210 Biz Center
Sweepstakes Center

C.O. BOA 1810-0002
Hours: Mon. to Sat. 10:00 am to 12 mid.
Sun: 4:00 pm to 12 mid.

RE: BOA1810-0002 Conditional Use Permit
PIN: 0526-70-6825.000

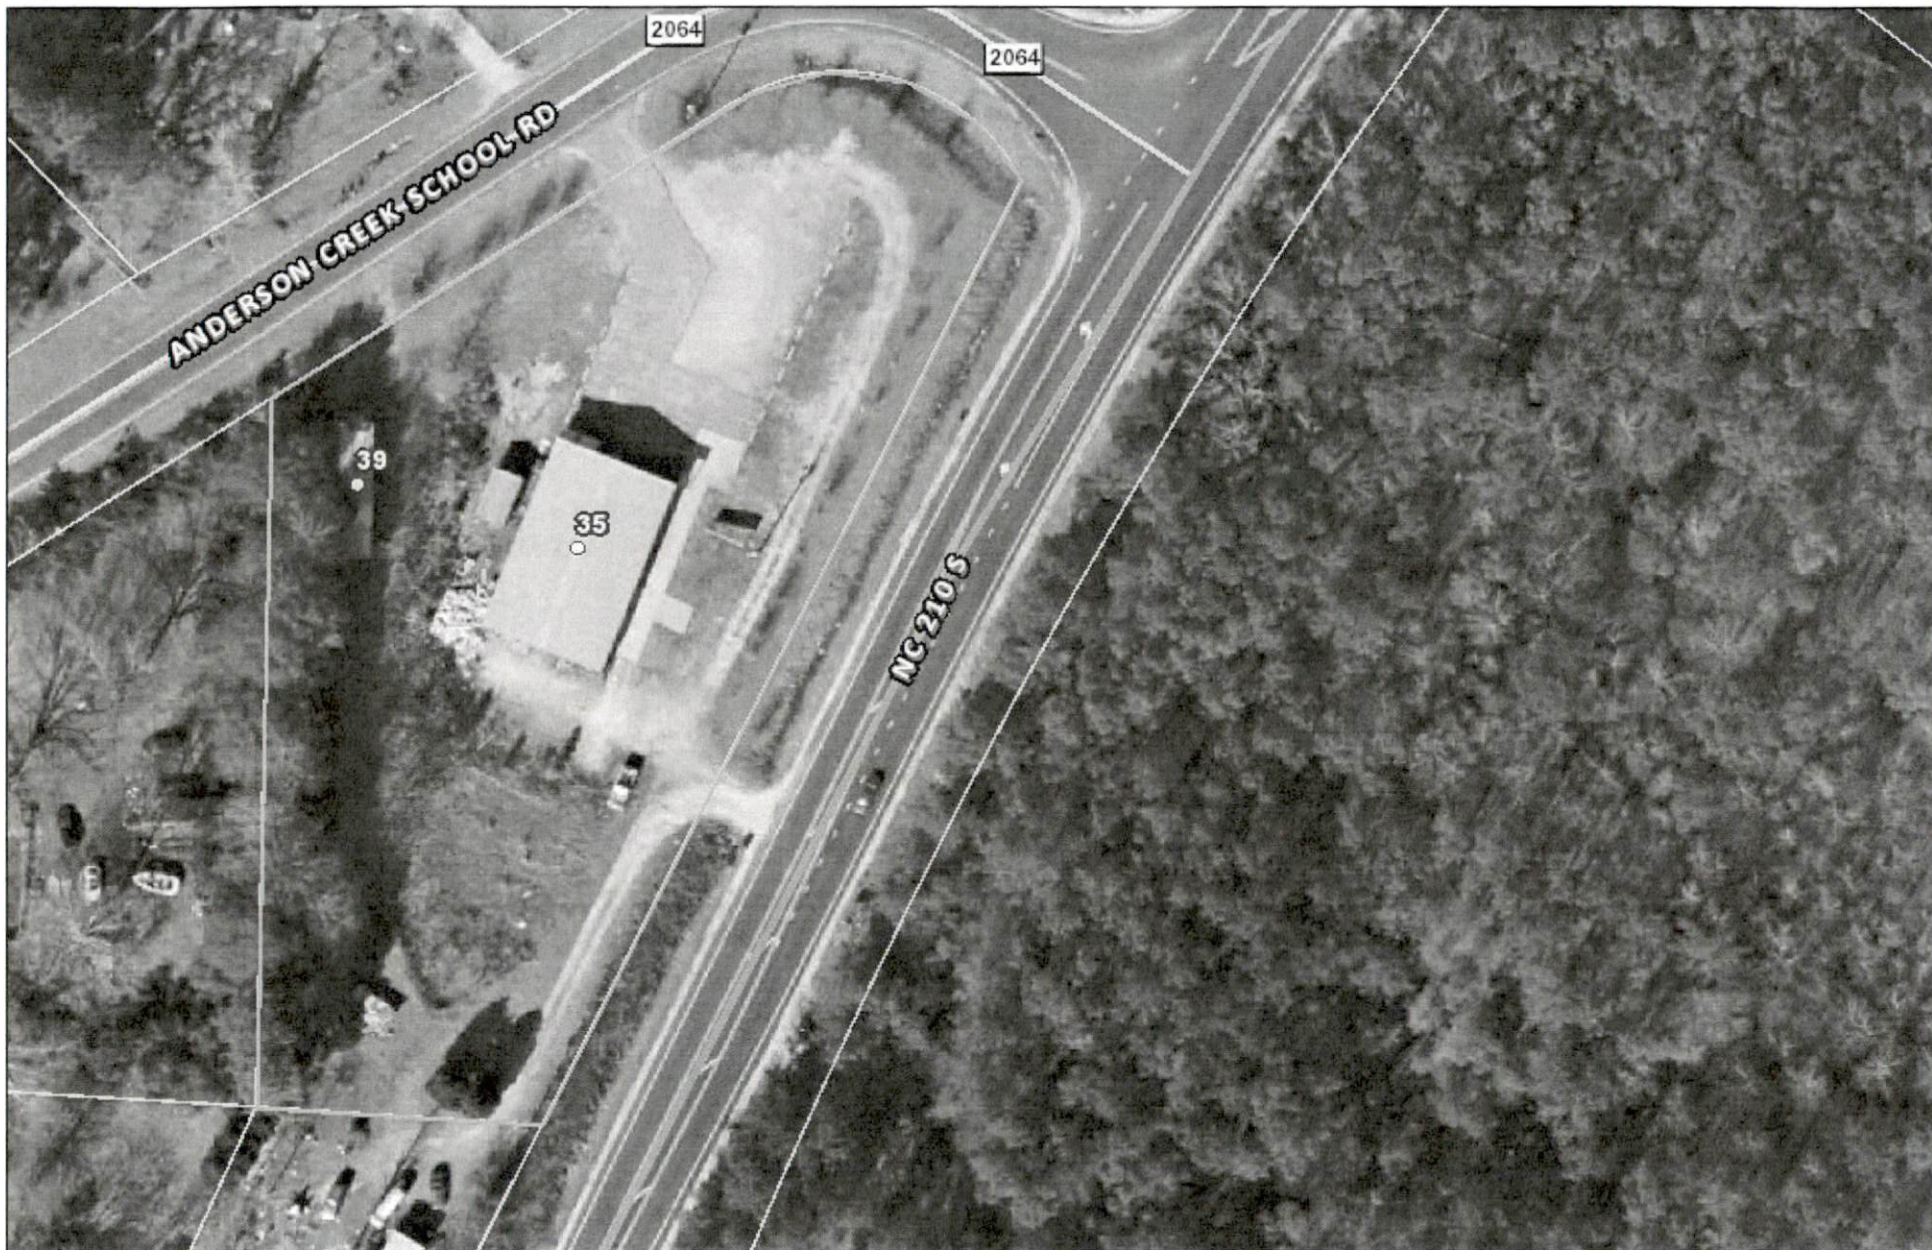
Site Plan should show:

- owner contact info ✓
- existing parking spaces ✓
 - should be a parking stop/ bumper in front of each spot.
 - each spot should be at least 9' x 18'
- all existing landscaping/ buffering ✓
- business name, type of business ✓
- any business sign will need its own, separate permit ✓
- Conditional Use permit #BOA1810-0002 ✓
- list the Board required conditions... ✓
 - Hours of Operation Mon-Sat 10am-12 midnight, Sun 4pm- 12 midnight
